Phone: 0300 123 6780
Email: Kathryn.Walsh@lancashire.gov.uk
Your ref: 3/2025/0349
Our ref: 3/2025/0349/HDC/KW
Date: 04 June 2025

Location: Apple Tree Cottage 4 Orchard Cottages Branch Road Waddington
BB7 3HR
Proposal: Proposed single storey side extension and internal alterations
(pursuant to variation of condition 4 (Windows and Doors) and
condition 5 (Parking) on permission 3/2024/1028).
Grid Ref: 372959 443887

Proposed Site Plan
Scale (1 : 500)

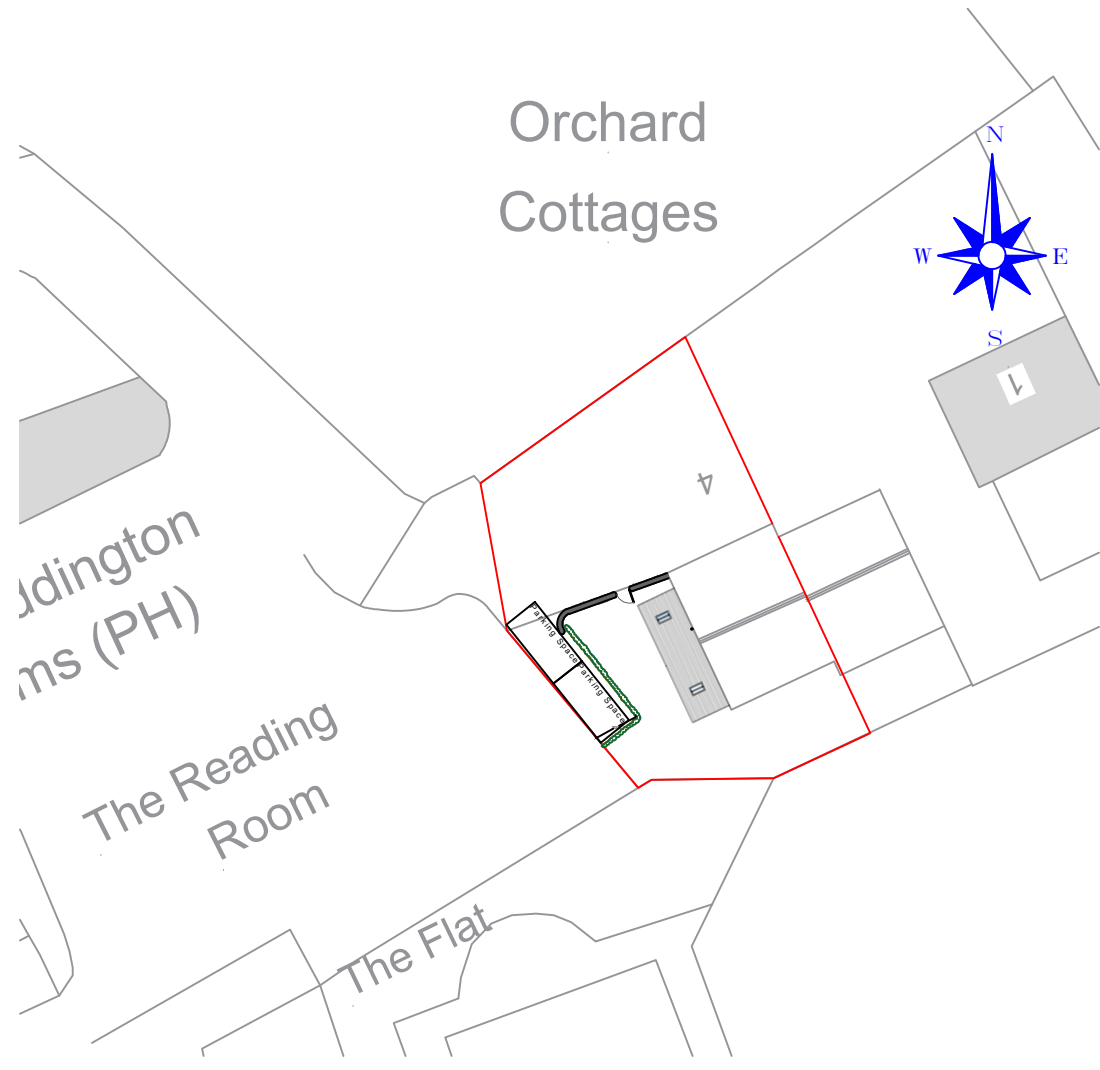
The LHA have reviewed drawing number 003 Revision H and note that there are 2 off street parking spaces which complies with the LHAs parking standards as defined in the Joint Lancashire Structure Plan. Both parking spaces measure 2.4m wide and an

additional 0.6m has been provided to support access due to the area being obstructed by a wall and hedge as well as being 5m in length.

1. The development hereby permitted shall be brought into use until the car parking and turning areas shown on the approved plan(s) have been provided in full and are available for use. The car parking and turning areas shall thereafter be kept available for the parking and manoeuvring of vehicles at all times.
